CDS is requesting comments on the following plat application: LP-24-00003 Suncadia Ph 2 Div 7.

In future correspondence please refer to:  
Project Tracking Code: 2024-07-04877  
Property: Kittitas County\_Suncadia Phase 2 Division 7 (LP-24-00003)  
Re: Survey Requested

**TO:** All Staff  
**FROM:** Public Works Plan Review Team  
**DATE:** July 15, 2024  
**SUBJECT:** LP-24-00003 Suncadia Ph 2 Div 7

NELSON STREAM
PRELIMINARY PLAT

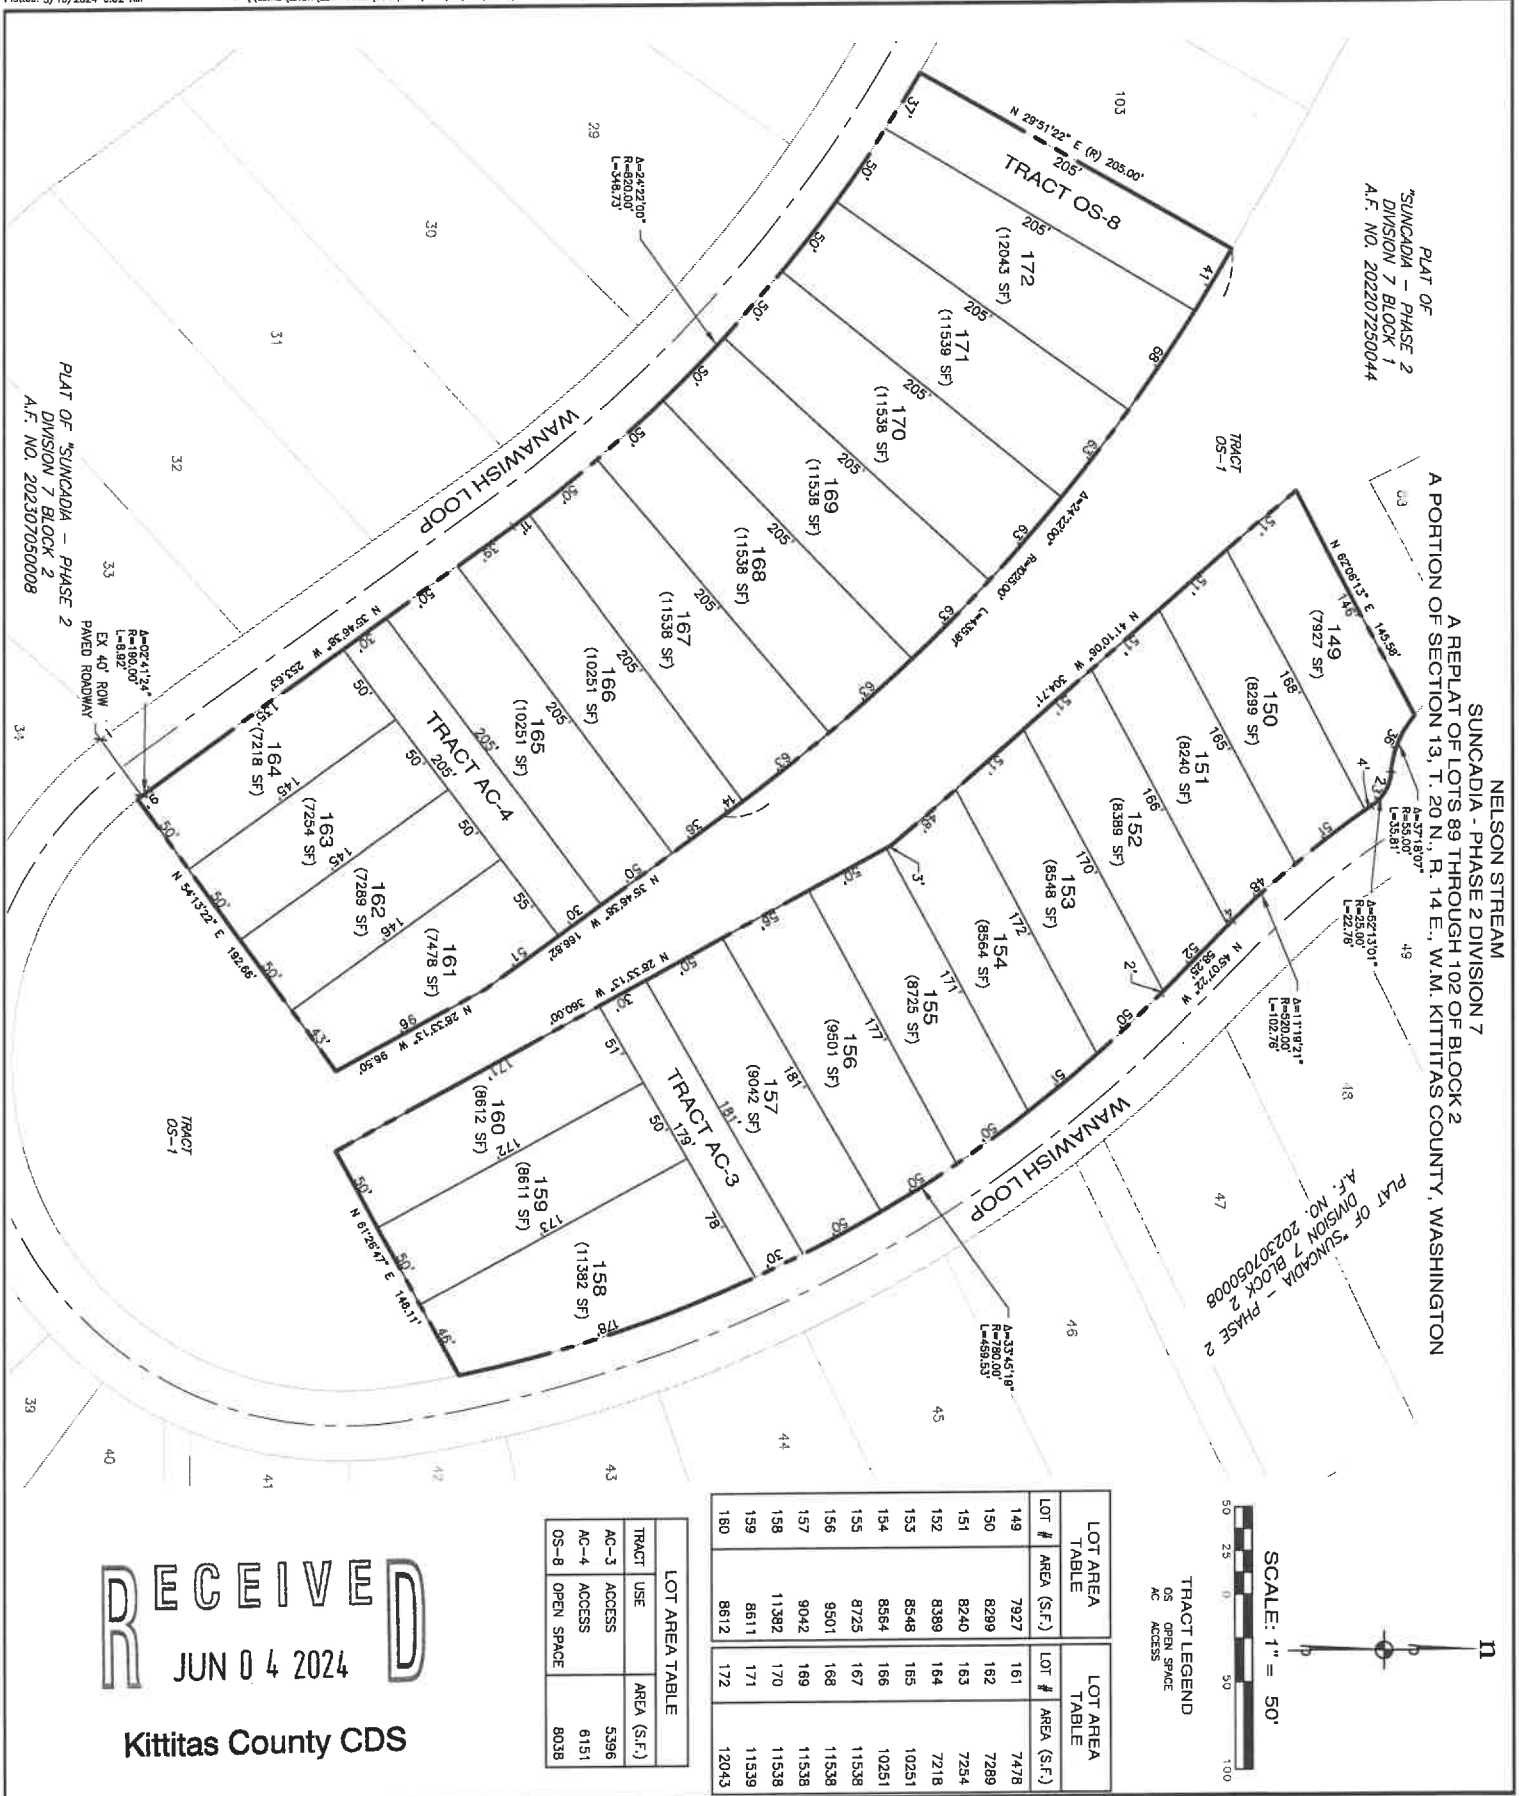
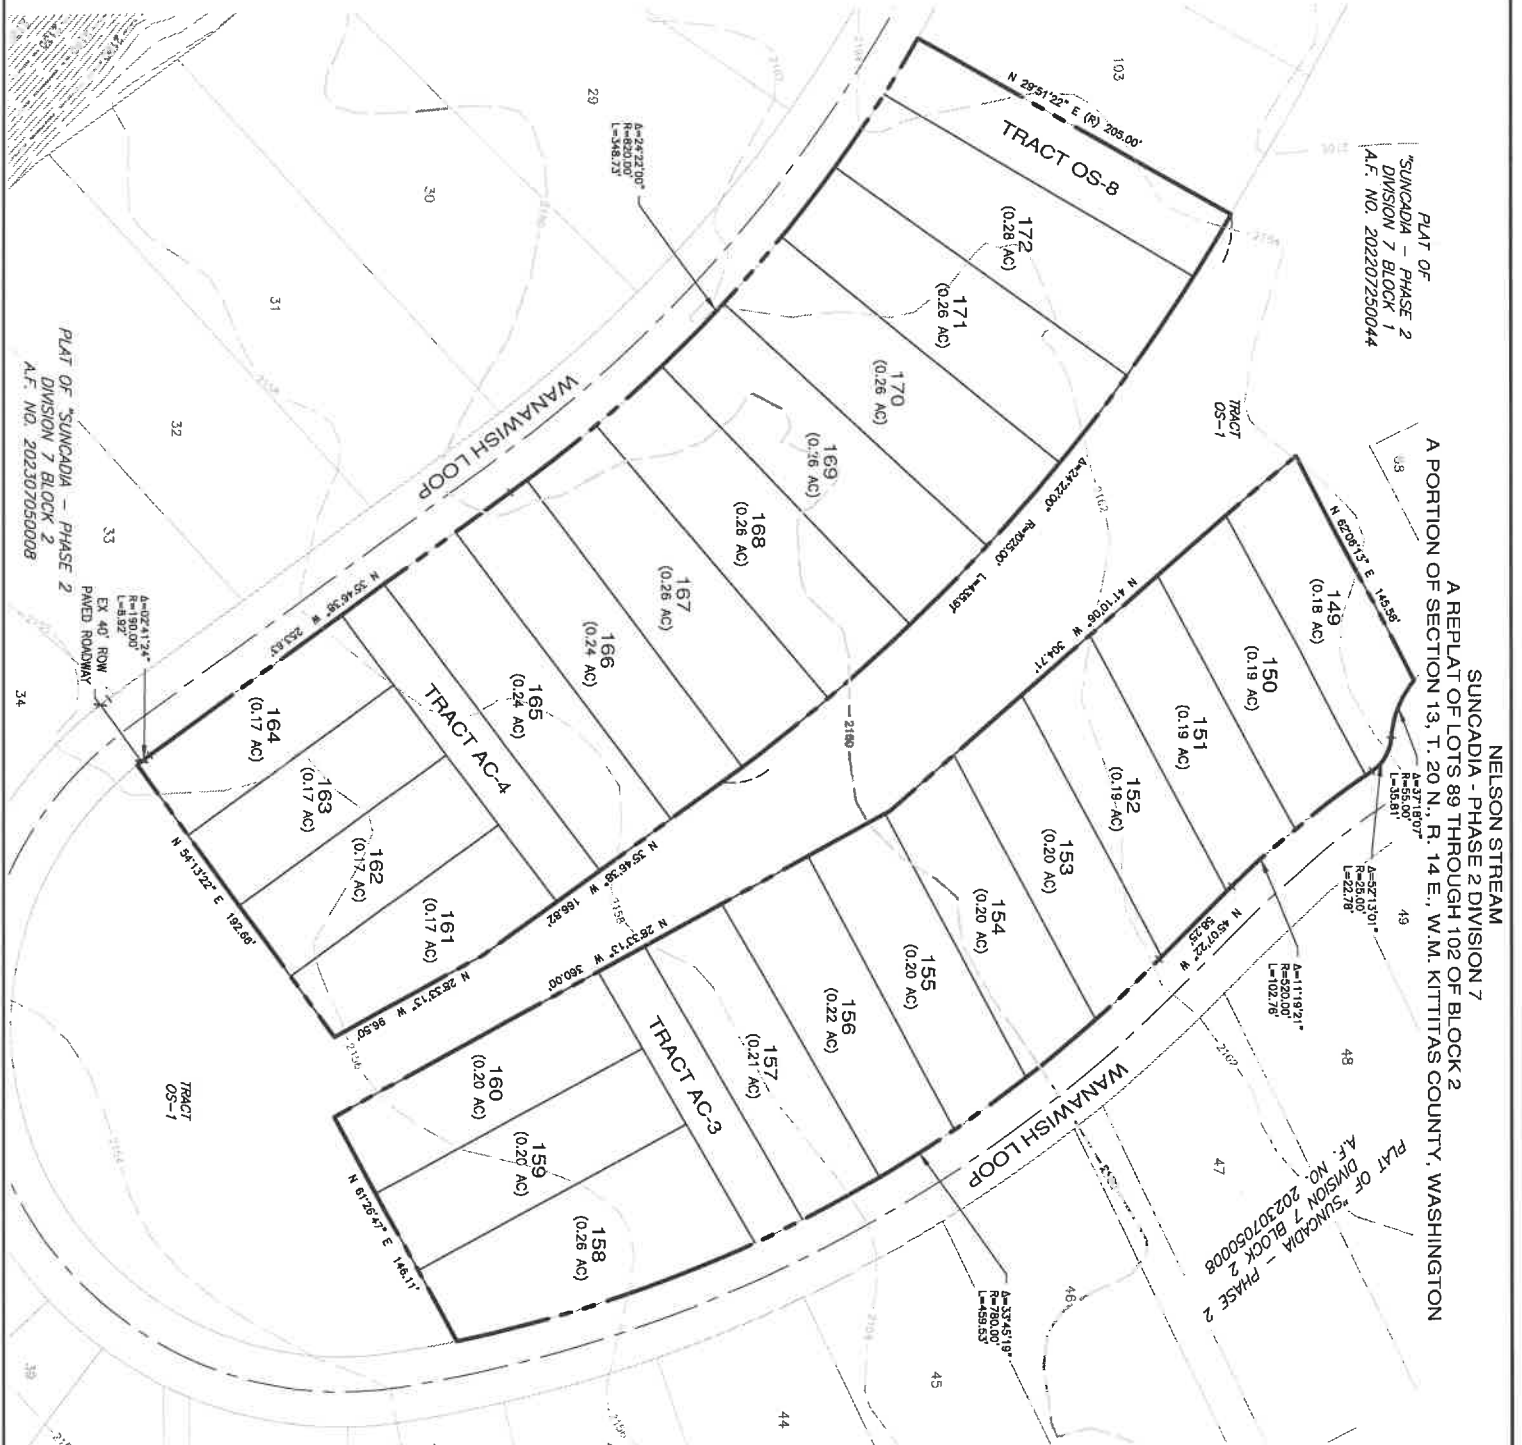
<b>ACCESS</b>	No comments. (JS)
<b>ENGINEERING</b>	<ol style="list-style-type: none"><li>1. Please provide an inventory of equivalent residential units, or the accounting method utilized in the water system plan, affirming sufficient capacity serving the plat.</li><li>2. Please provide an inventory of equivalent residential units, or the accounting method utilized in the general sewer plan, affirming sufficient capacity serving the plat.</li><li>3. Public Works will reserve additional engineering comments for the Civil Review process. (CP)</li></ol>
<b>SURVEY</b>	<p>No additional survey requirements as part of the preliminary Long Plat.</p> <p>For final Long Plat, the following will need to be included:</p> <ol style="list-style-type: none"><li>4. Controlling corners will need to be shown.</li><li>5. As a minimum, corners between new division lines shall be set and shown on the face of the plat.</li><li>6. Wanawish Loop shall be identified as being a "Private 40' Paved ROW". (JT)</li></ol>
